From: Simon Davis
Sent: 29 September 2017 11:15
To: 'Dawn Appleton'
Subject: RE: Ashurst Close, Bersted BE/83/17

DRAWING TITLE Site Plan and Street Elevations			
DATE	SCALE	DRAWN BY	GIM
March 2017	1:200 @ A2	CHECKED BY	
JOB NO.	DRAWING NO.	REVISION	
1690	2.02

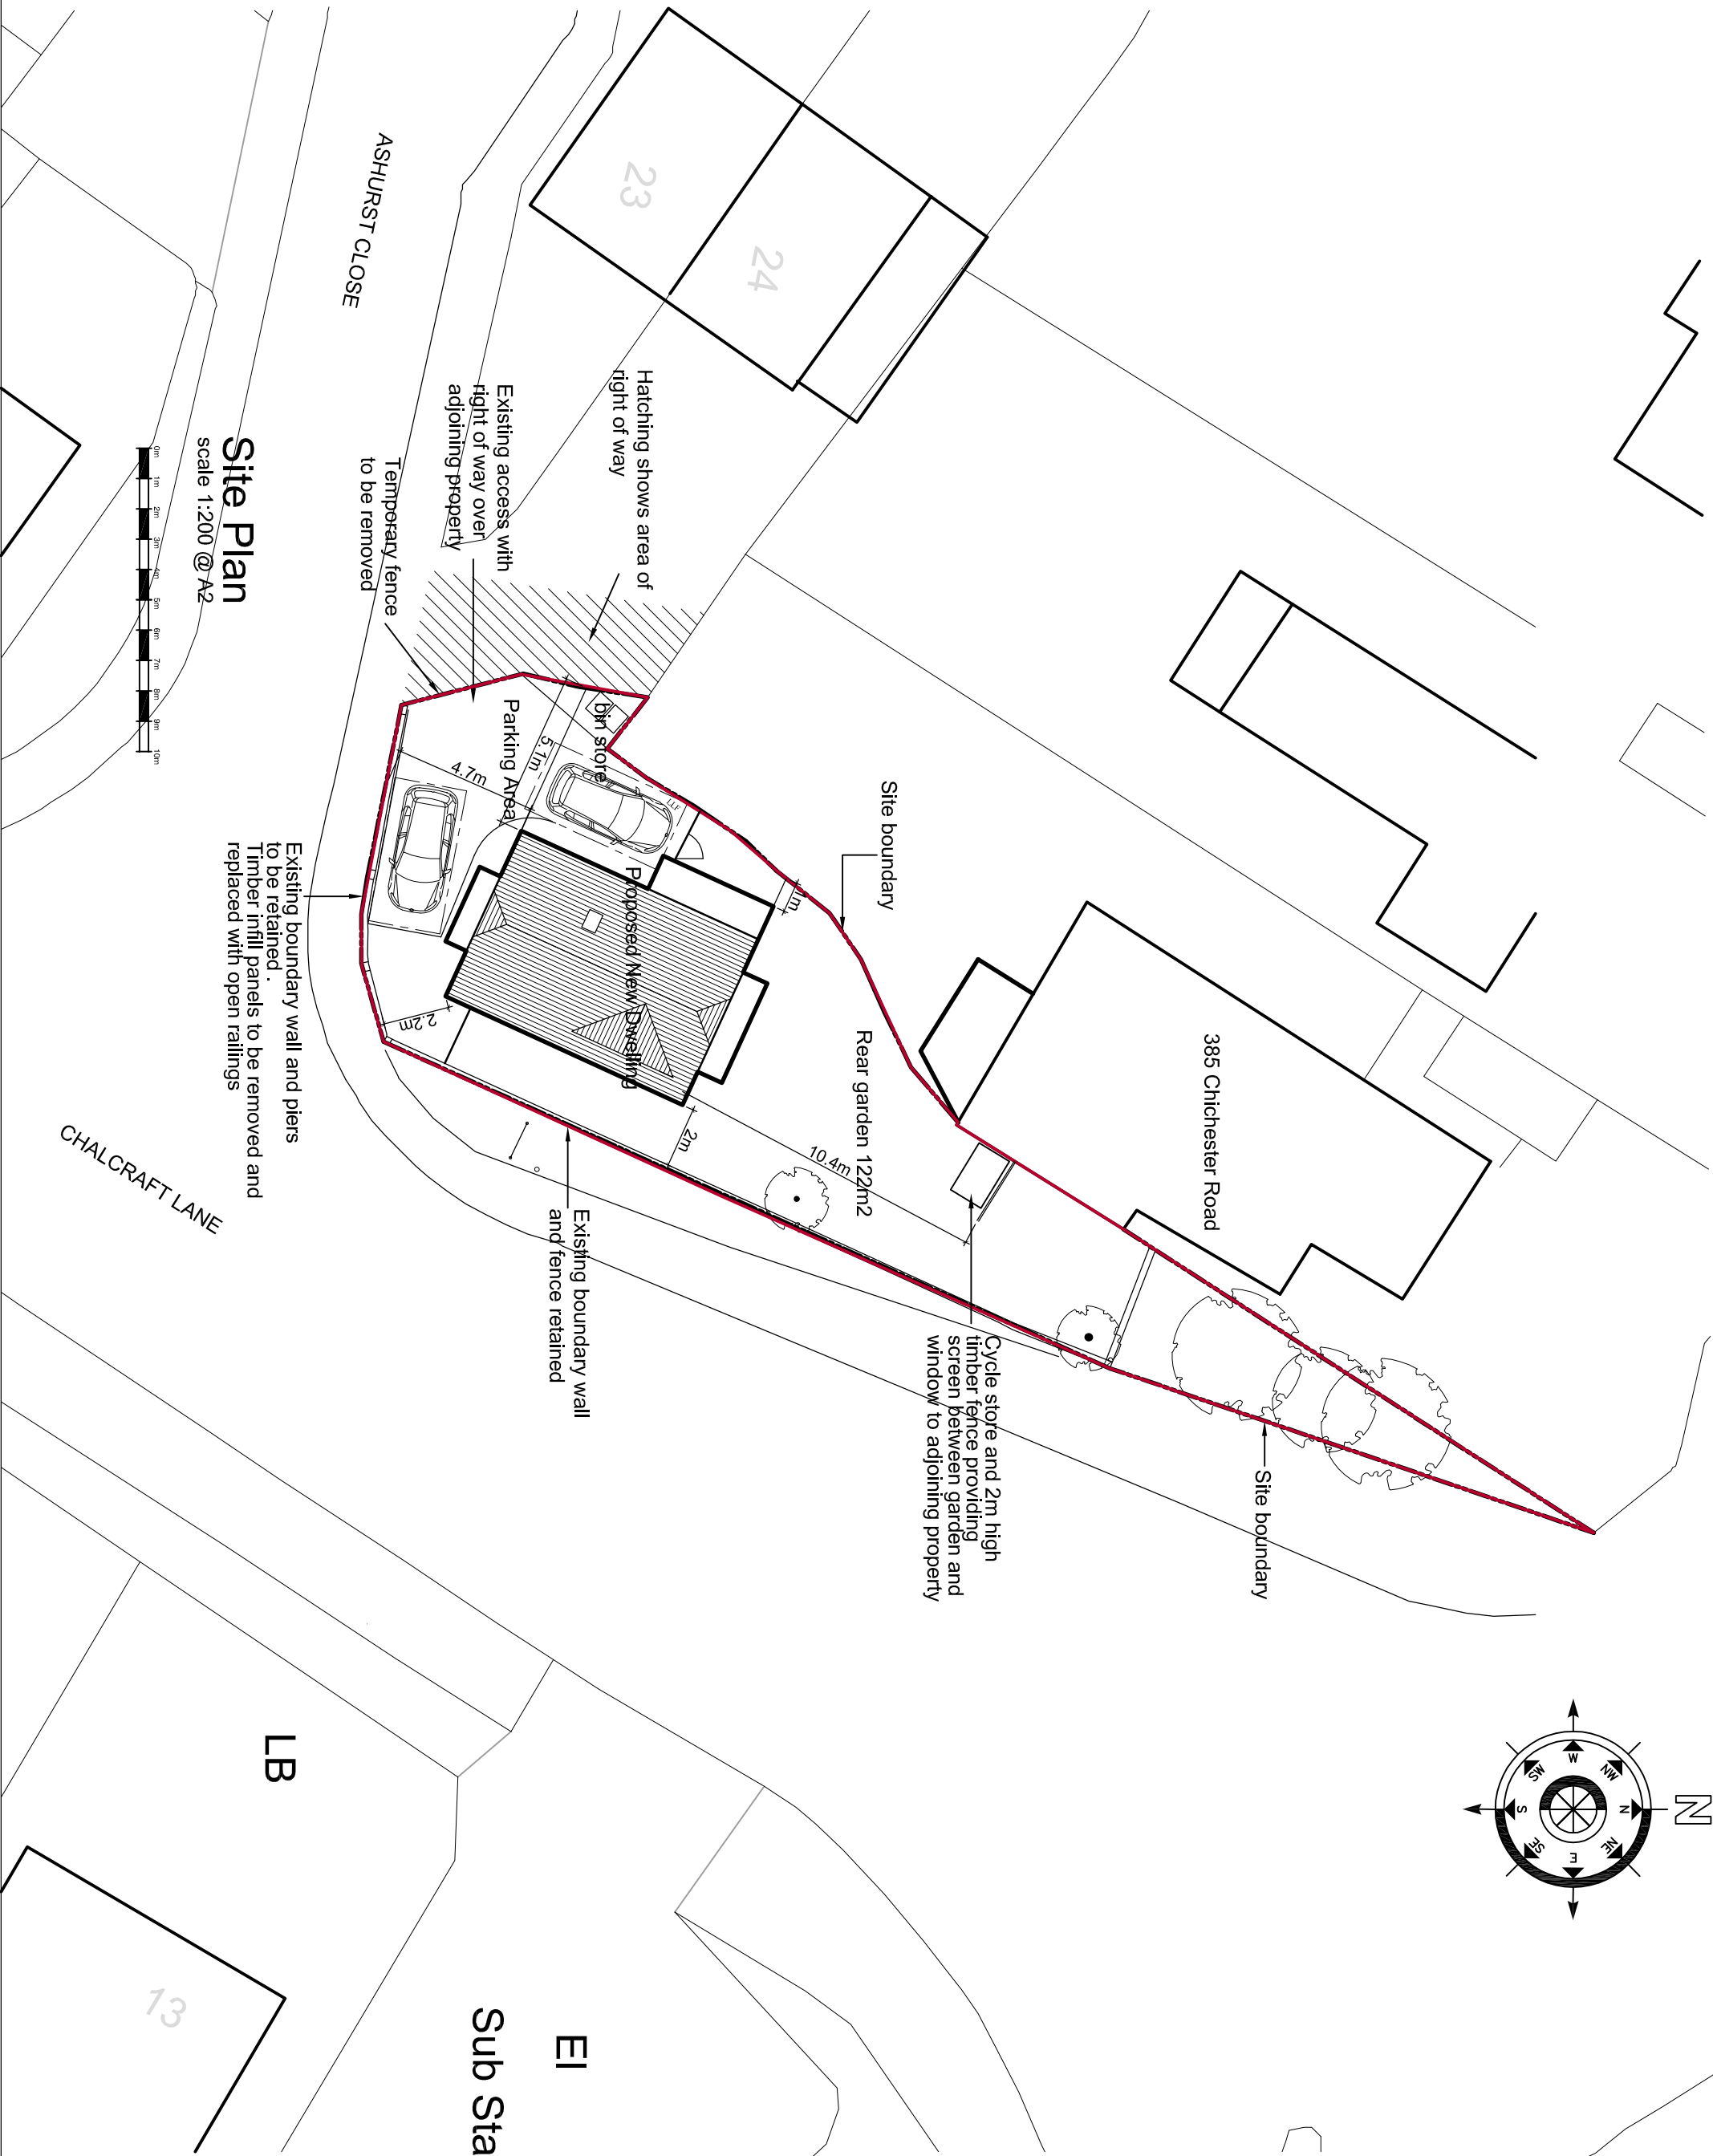
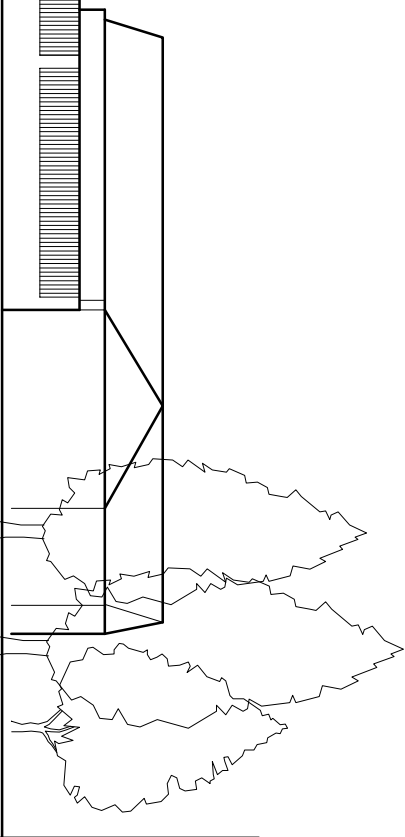
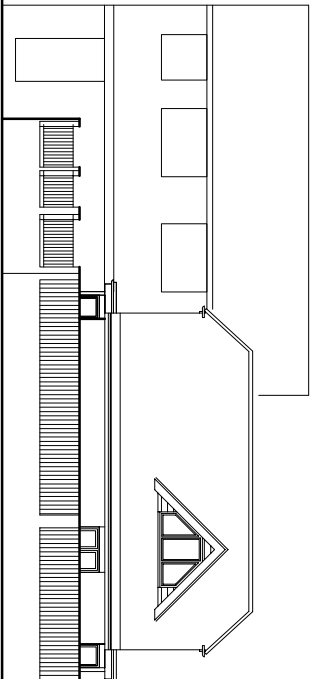
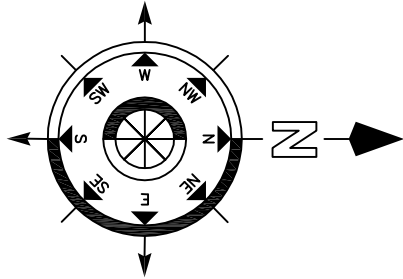
I have spoken with Dan about this one and I'm afraid that we won't be able to support it and would instead refuse on grounds of being out of character with the surrounding built form.
